From: Mark Warwick
Sent: 31 January 2018 09:24
To: Anita Gardner
Subject: AB/148/17/PL

Planning Application Ref: AB/148/17/PL

Location: Wooded Land South West of Dalloway Road, Arundel

Description of works: To provide 4 No. detached houses on existing semi natural woodland site. This application is a Departure from the Development Plan.

Proposed Trees to be removed

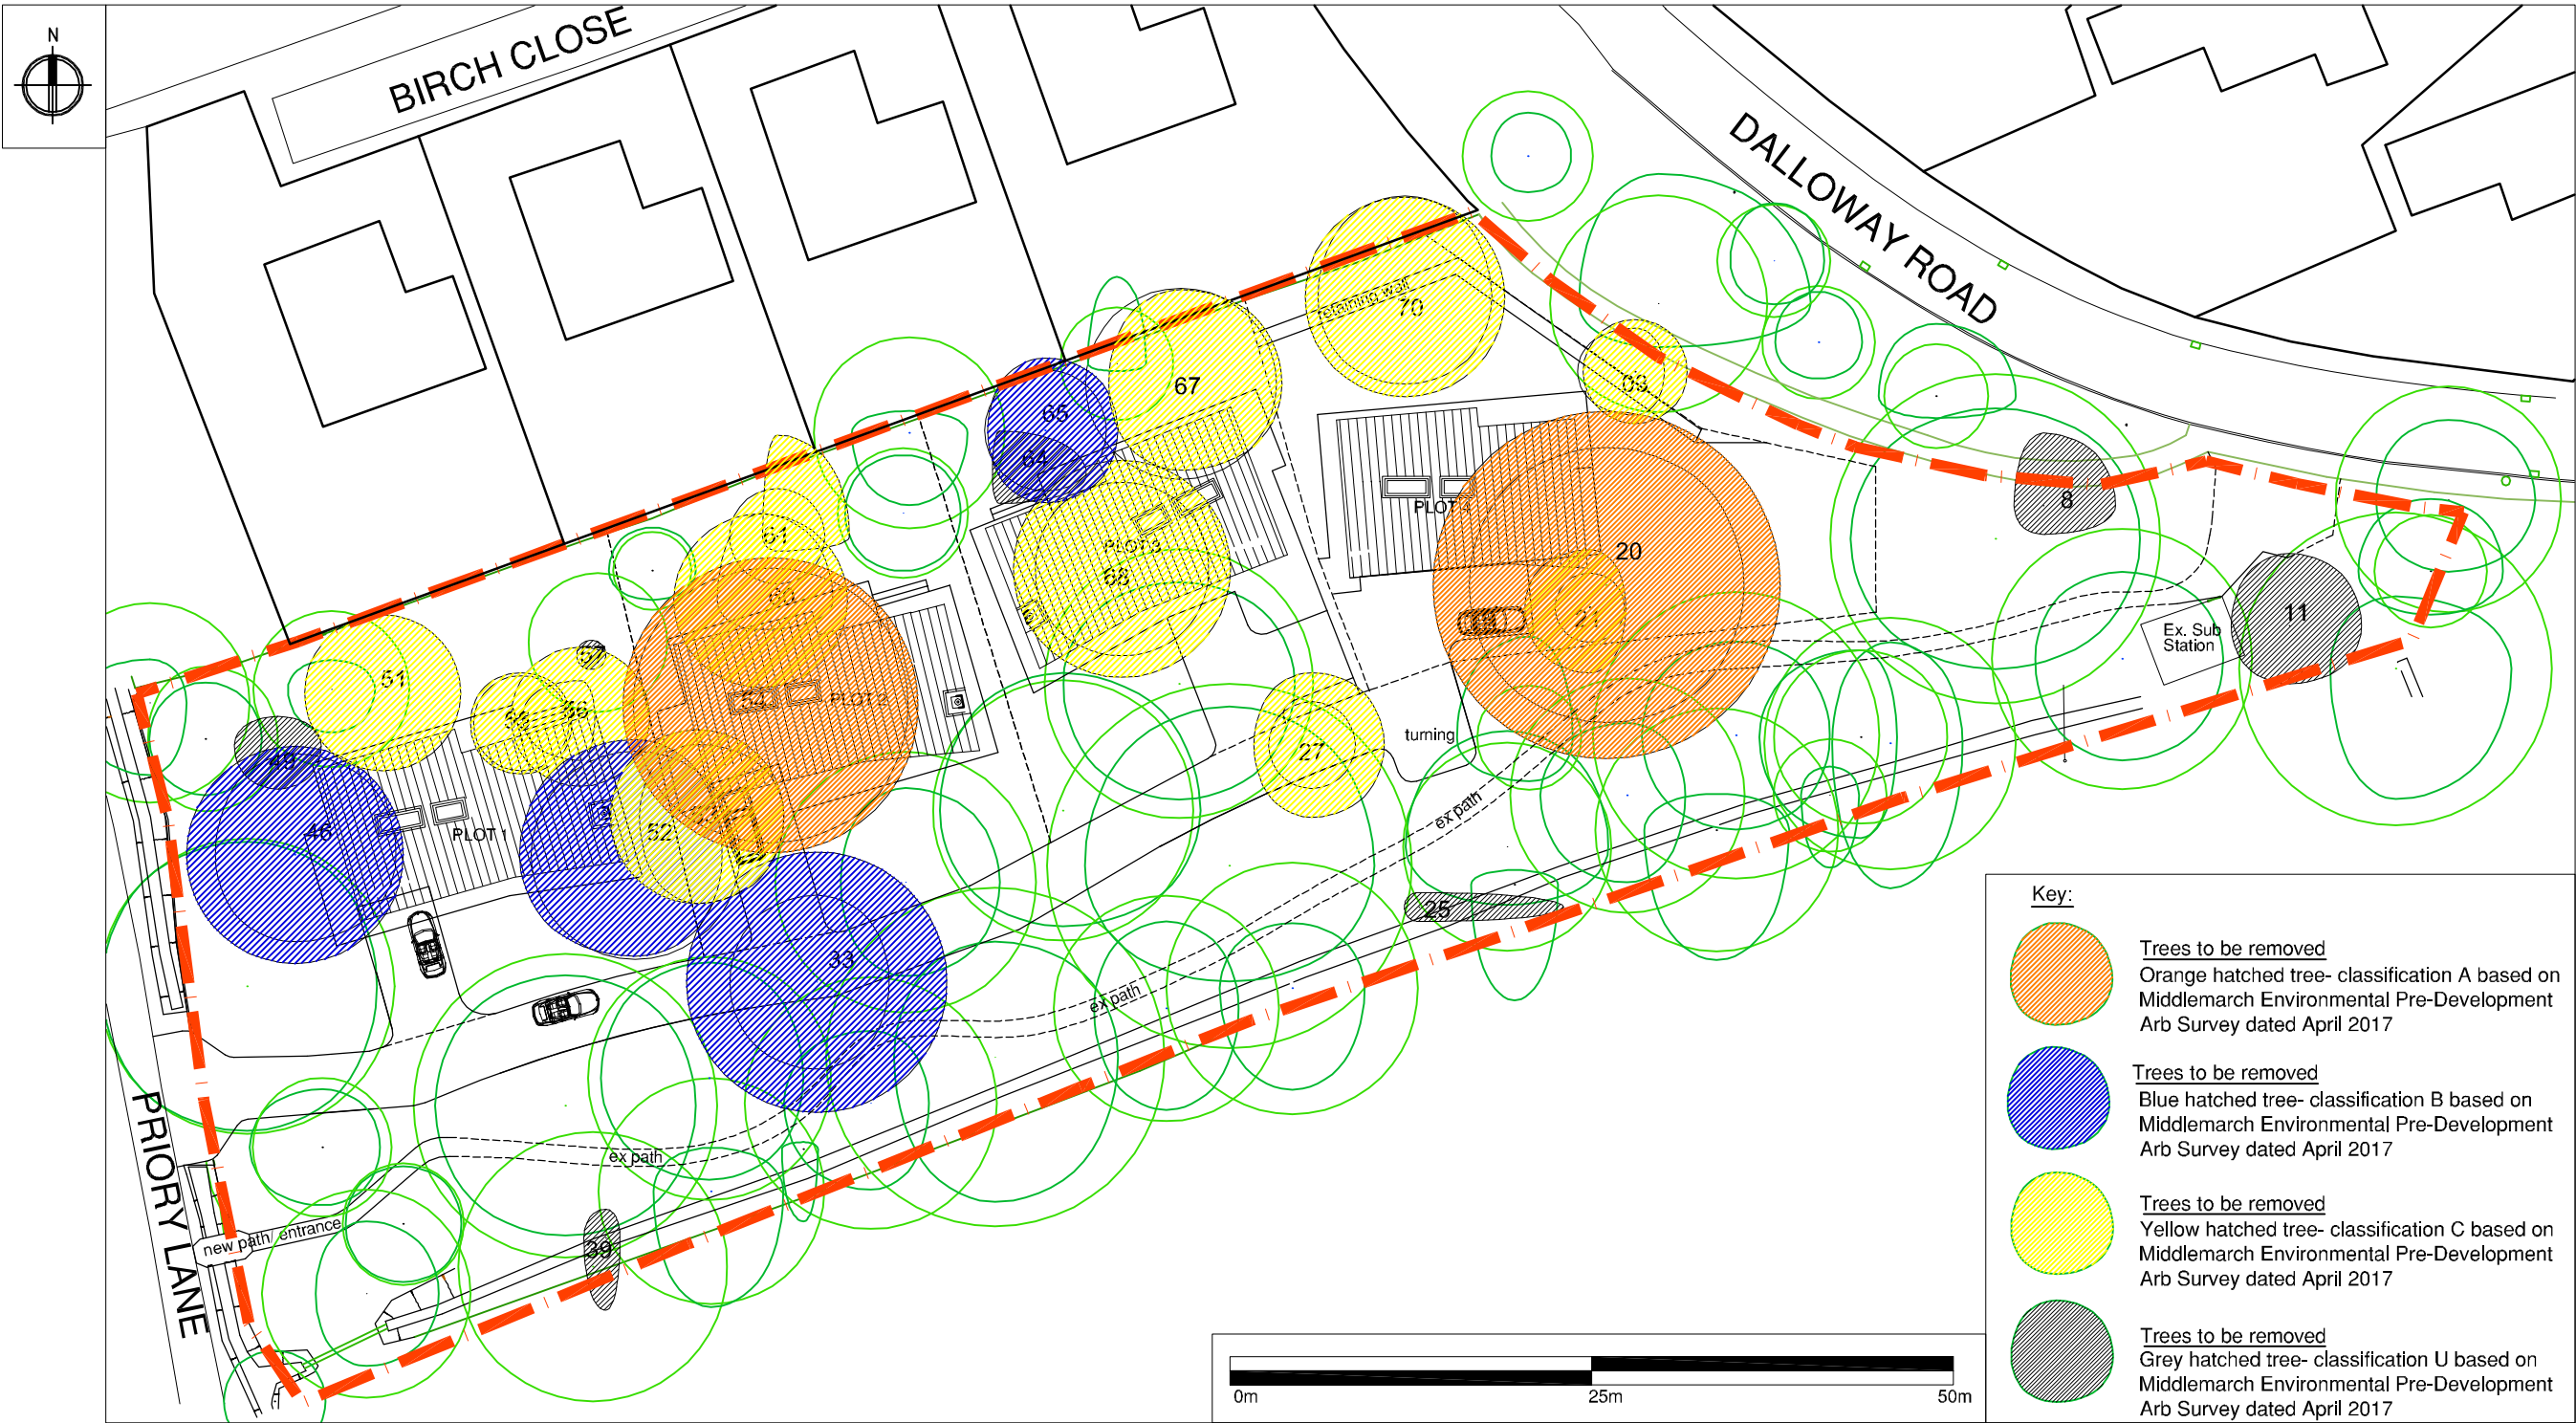
- It makes a significant contribution to, and has a long-standing relationship with the local landscape.
- Among the list of trees proposed for removal are several good quality specimens of significant stature, which contribute significantly to the value and character of this woodland.

- In respect of trees marked for retention, these will inevitably come under pressure to be pruned as they would overhang gardens, buildings and driveways. The majority grow on the southern aspect of proposed dwellings; bearing shade and discarding debris onto the same during periods of inclement weather which is likely to generate some concern thereby adding further pressure.
